CITY OF ALBUQUERQUE

Re: St. Jude Thaddeus Church, 5712 Paradise Blvd. NW
Request for C.O.—90 Day Temporary Approved
Engineer's Stamp dated: 10/14/10 (B-11/D003)
Certification dated: 10-13-11

CONCEPTUAL
GRADING & DRAINAGE PLAN

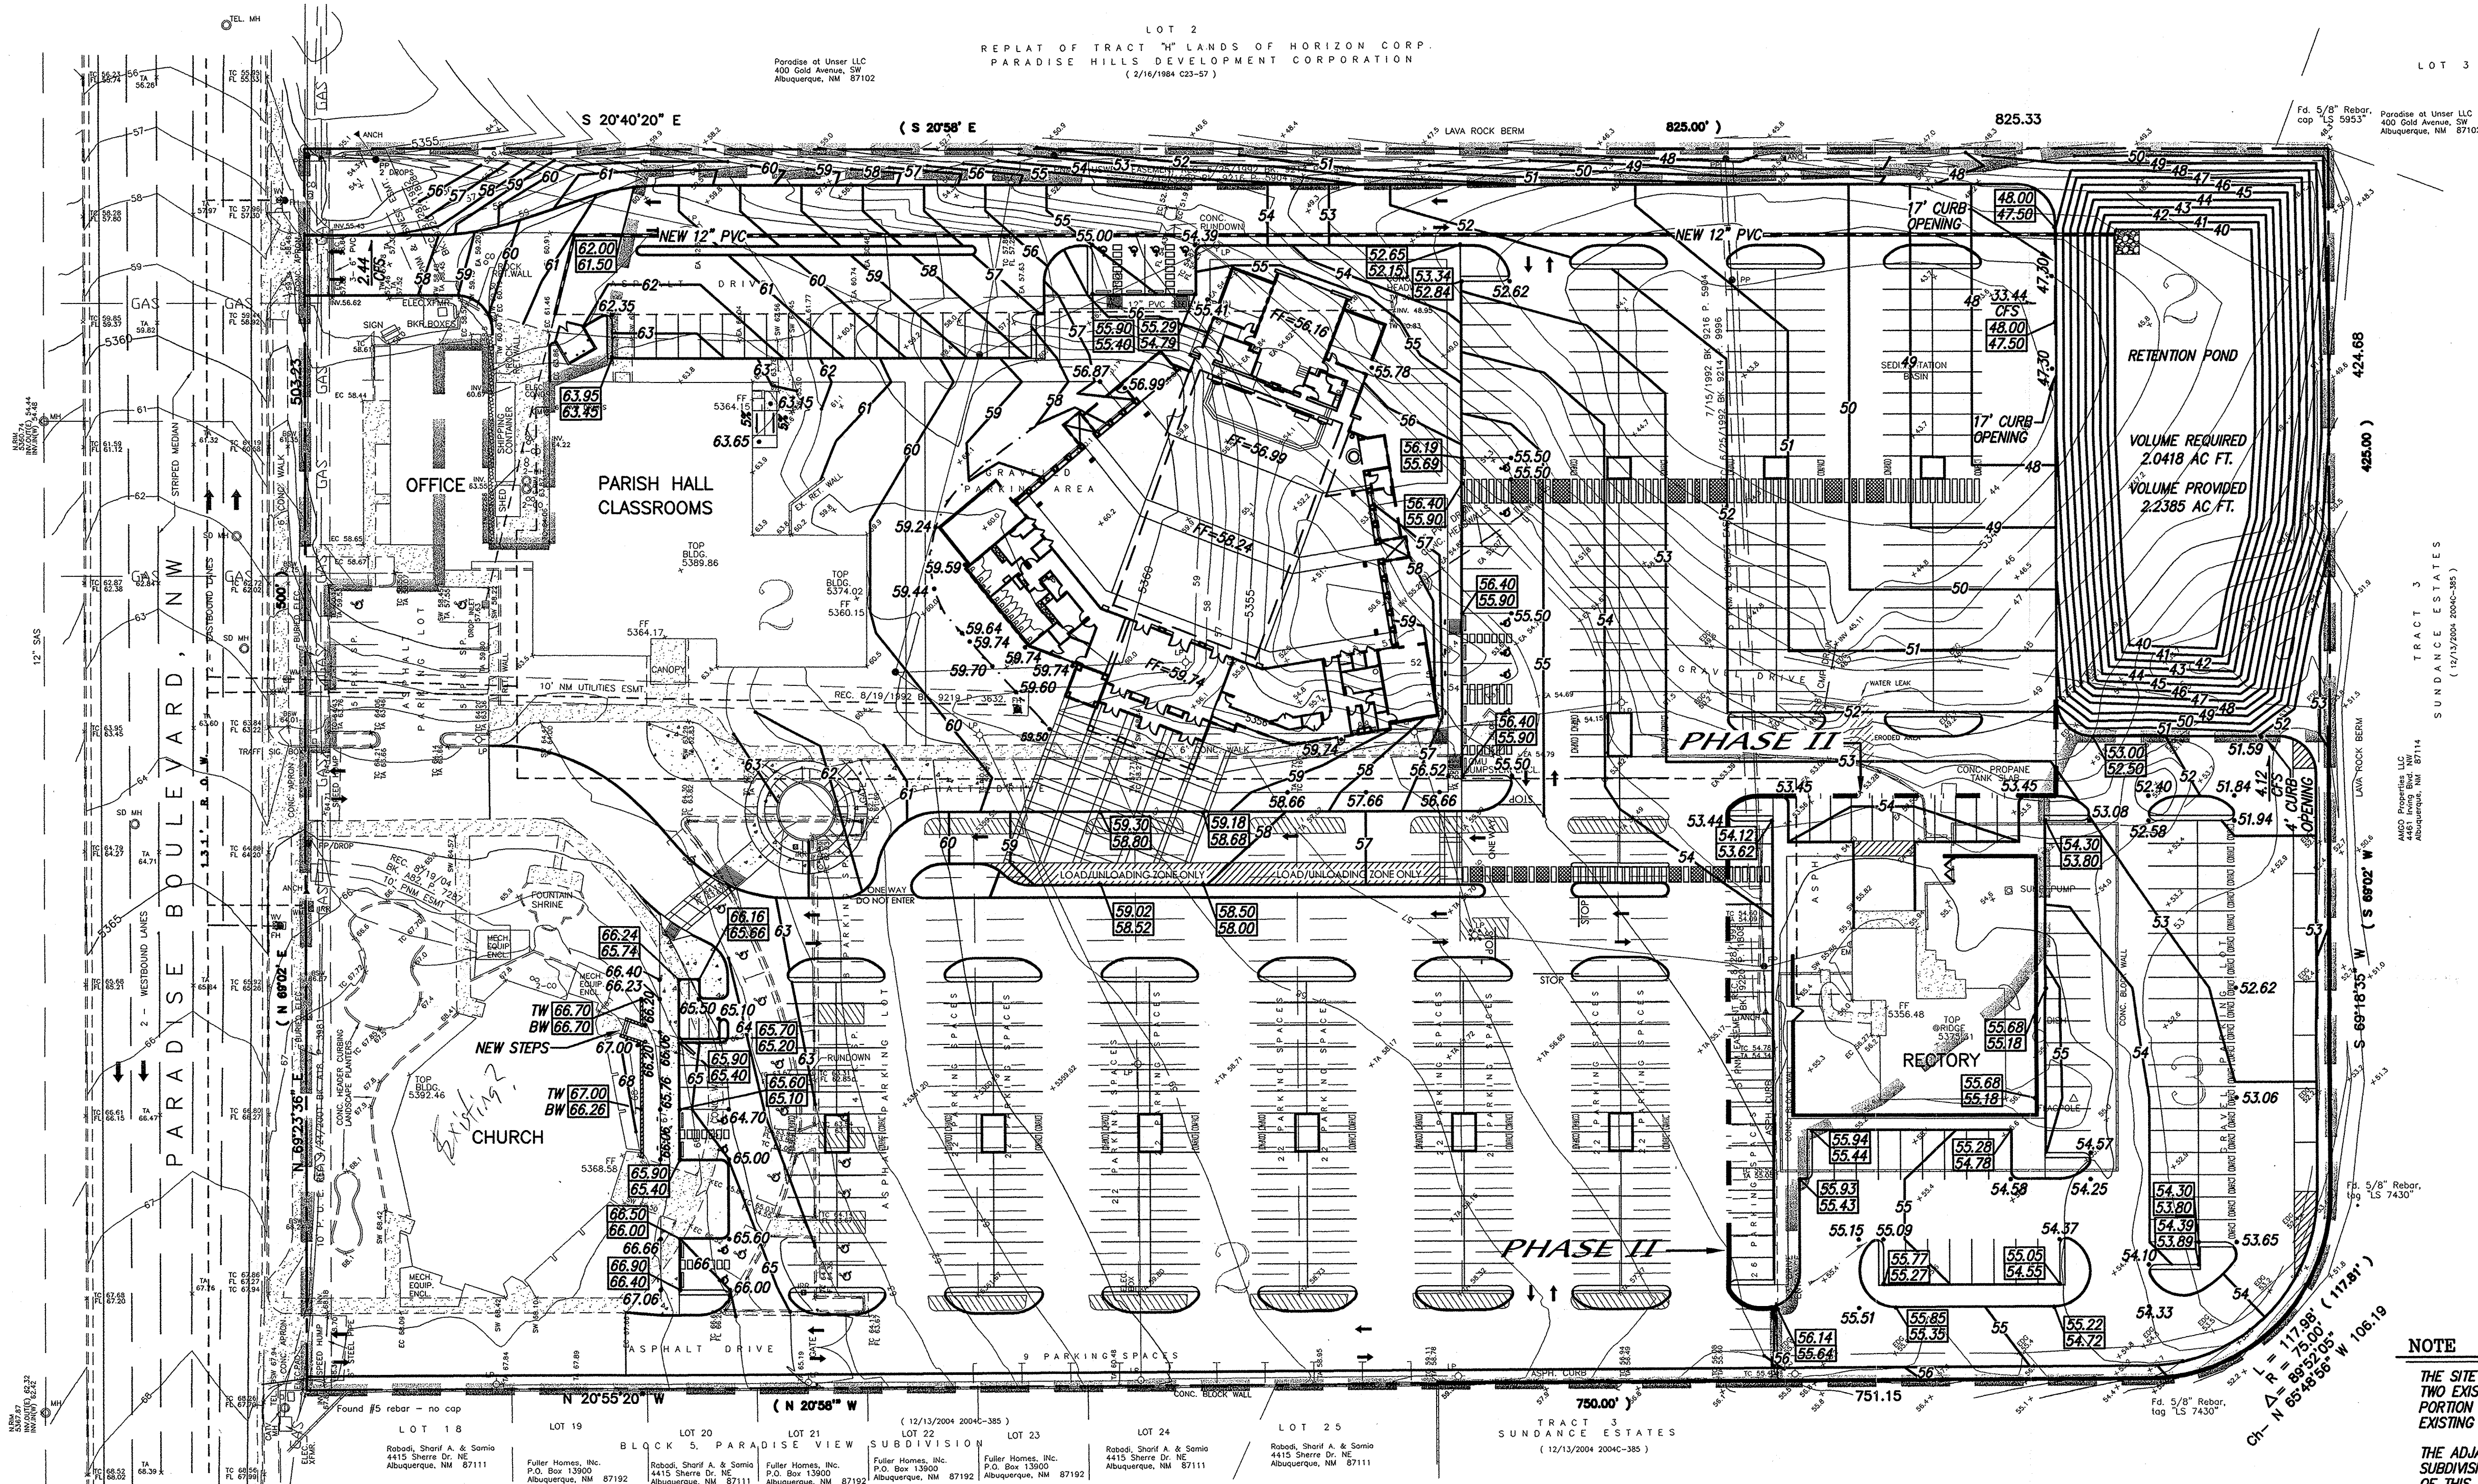
- The pond volume should be certified.
- Due to the north and east sides of the retention pond being a 1:1 slope an engineered means of erosion control is required. Rock plating may be applicable in this application.
